Reference No:	2024/62/93625/W
Site Address:	94, Victory Avenue, Paddock, Huddersfield, HD3 4HF
Description:	Erection of rear dormer extension and increase in roof height
Recommending Officer:	Joshua Merriman

DECISION – REFUSED

Officer Report – 2024/93625

1. PROPOSED FRONT ELEVATION

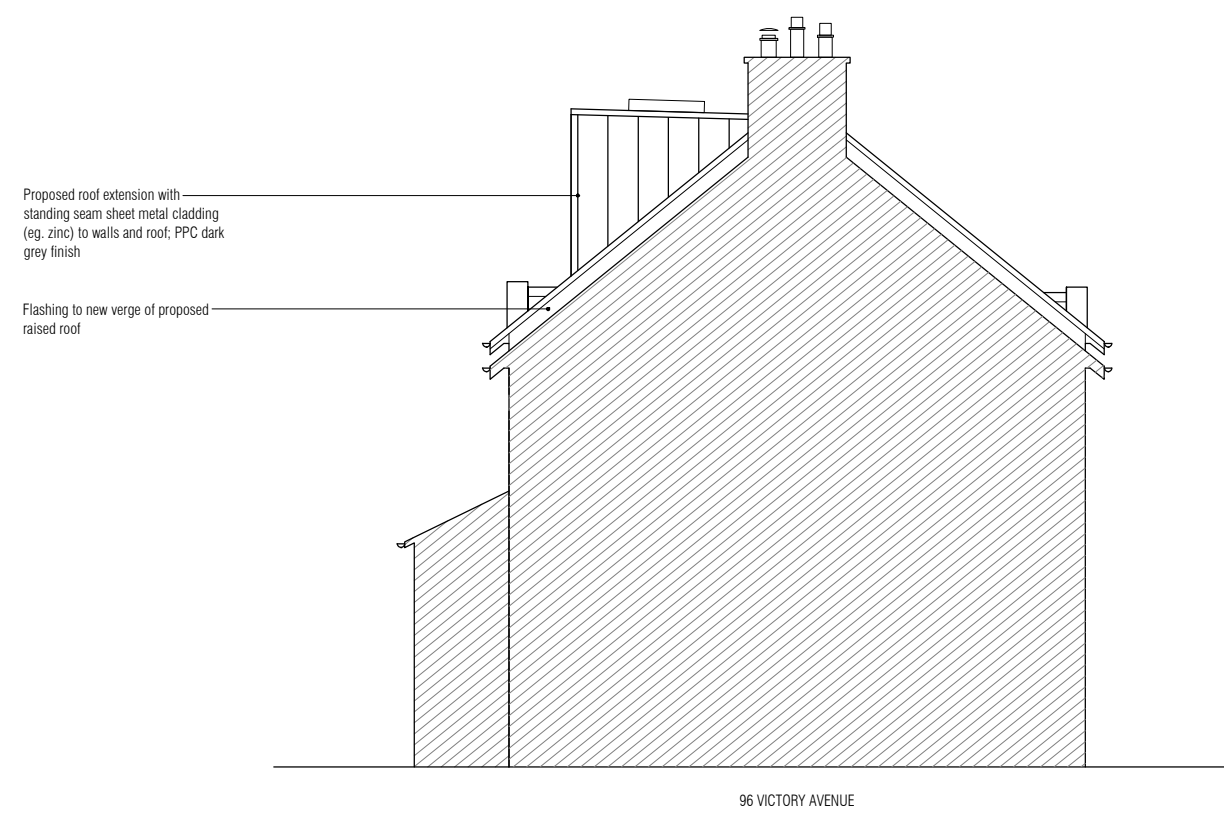
The raising of the eaves would see the stepped nature of the row of terraced properties interrupted, by brining the property higher than no.96, which is currently lower than. Whilst the stepped design in relation to no.94 and no.92 which is proposed would be in keeping with that of the existing terrace, this would be viewed in the contexts of the visual interruption caused by the building being higher than the other property it would tie into (no.96).

It is considered the raising of the ridge and eaves in this case would lead to a visual intrusion which would be highly prominent and read from both Victory Avenue and Royds Avenue. This element of the scheme is considered to have a harmful visual impact within the street and wider locality and whilst use of matching materials would mitigate this harm to some degree it is not considered it would overcome the overall impact.

3. PROPOSED REAR ELEVATION

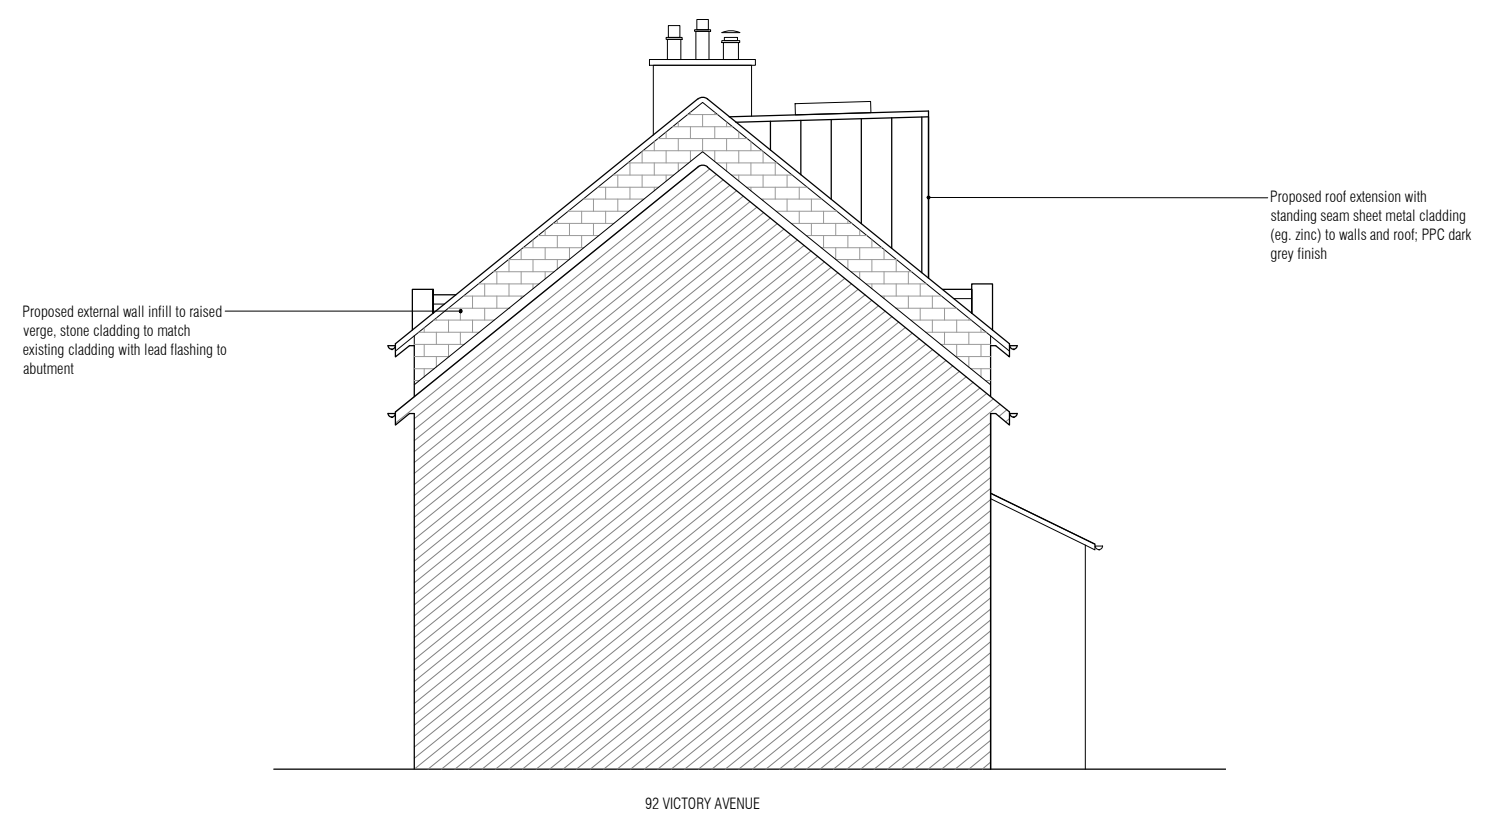
It is noted the submitted plans incorrectly annotate no.s 92 and 96 on the proposed rear elevation upon drawing 200P03. Notwithstanding this incorrect annotation the LPA is still able to determine this application on the basis of the submitted plans and information.

The dormer to rear is considered to be of a significant scale, in relation to the rear roof slope and would dominate the rear roof plane of the house, not retaining a substantial area of the original roof, and would appear as an unsympathetic to the host dwelling when viewed from Royds Avenue. The use of materials is considered to be a factor to which limited weight can be afforded in terms of mitigating the harmful impact of construction of the large structure to the rear roof slope. Furthermore, the introduction of the proposed dormer would detract from the existing gable feature within the rear roof slope and have a dominating impact when viewed in this context and the context of the wider row of properties which the dwelling forms a part.
